DRB Application No.: 08DRB-70374

Project # 1007441

Project Name: PARKLAND HILLS ADDITION

**CITY OF ALBUQUERQUE  
PLANNING DEPARTMENT  
September 3, 2008  
DRB Comments**

PLAT OF  
**LOTS 5-A, 10-A AND 11-A, BLOCK 61**  
**PARKLAND HILLS ADDITION**  
 ALBUQUERQUE, BERNALILLO COUNTY, NEW MEXICO  
 AUGUST 2008

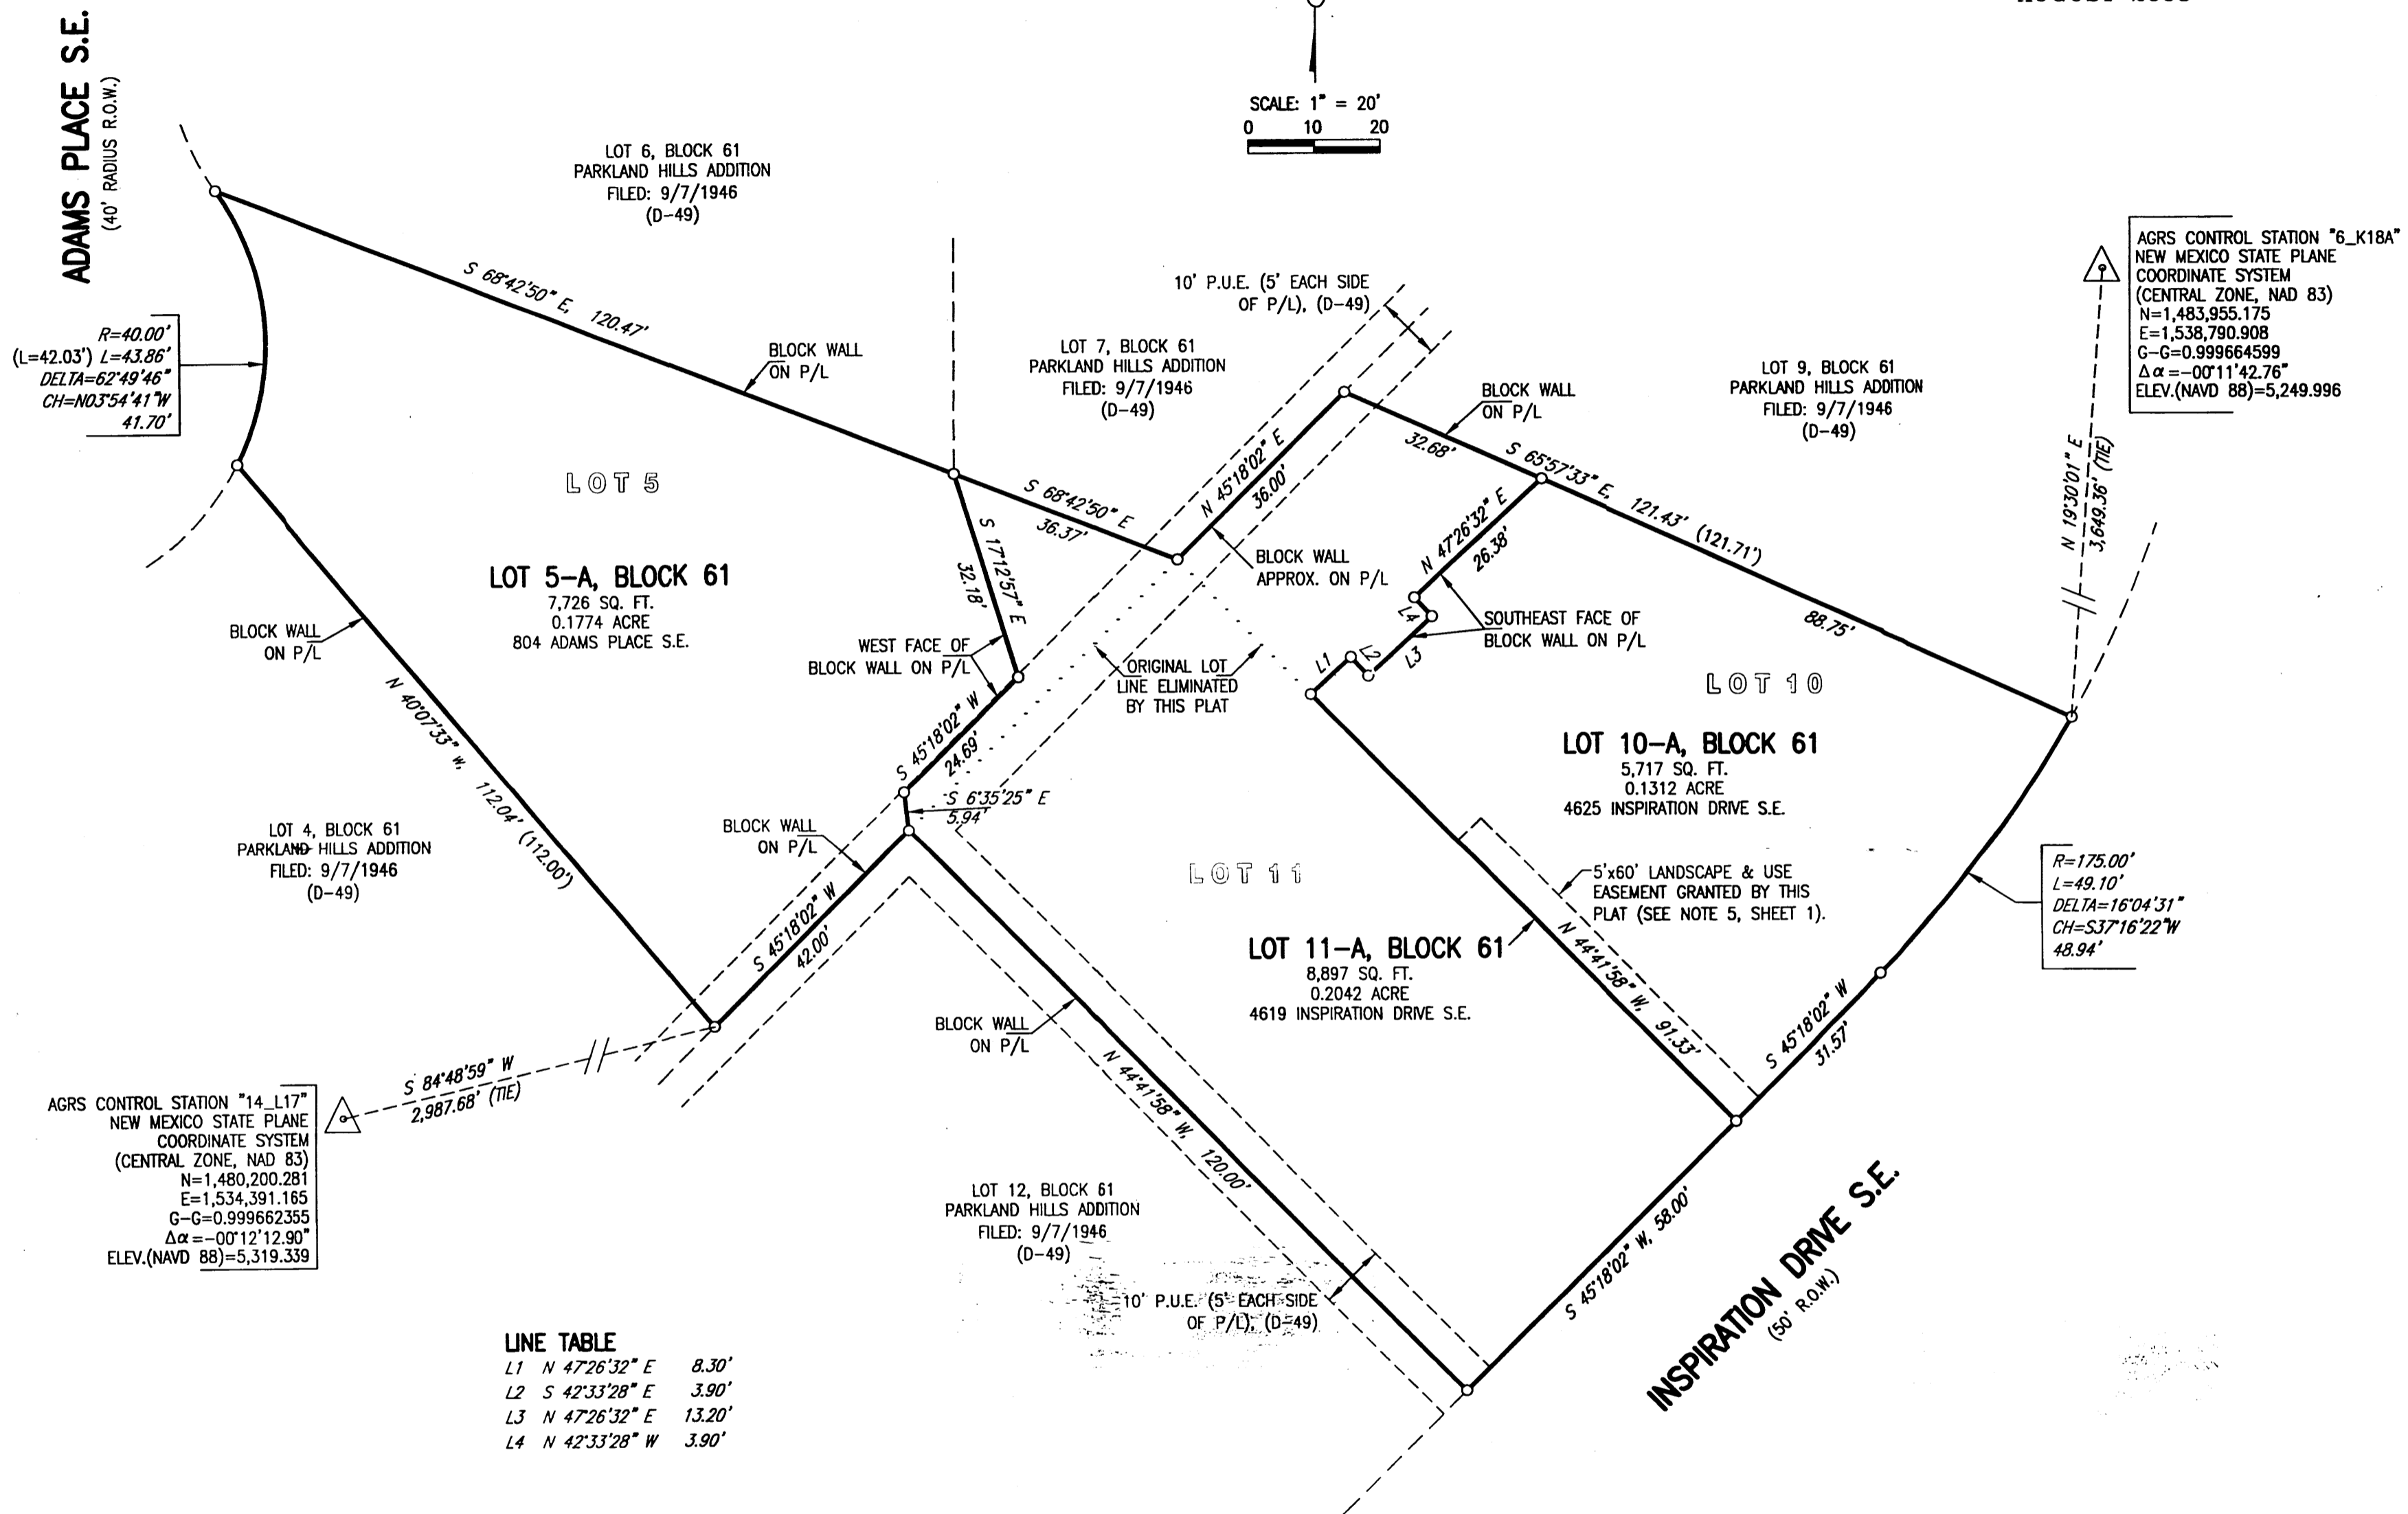
A detailed site plan that shows buildings and dimensions setbacks is needed to demonstrate that each lot can individually meet zoning requirements. A solar collector note per Section 14-14-4-7 of the Subdivision Ordinance is needed. Please remove Zoning note (No. 8).
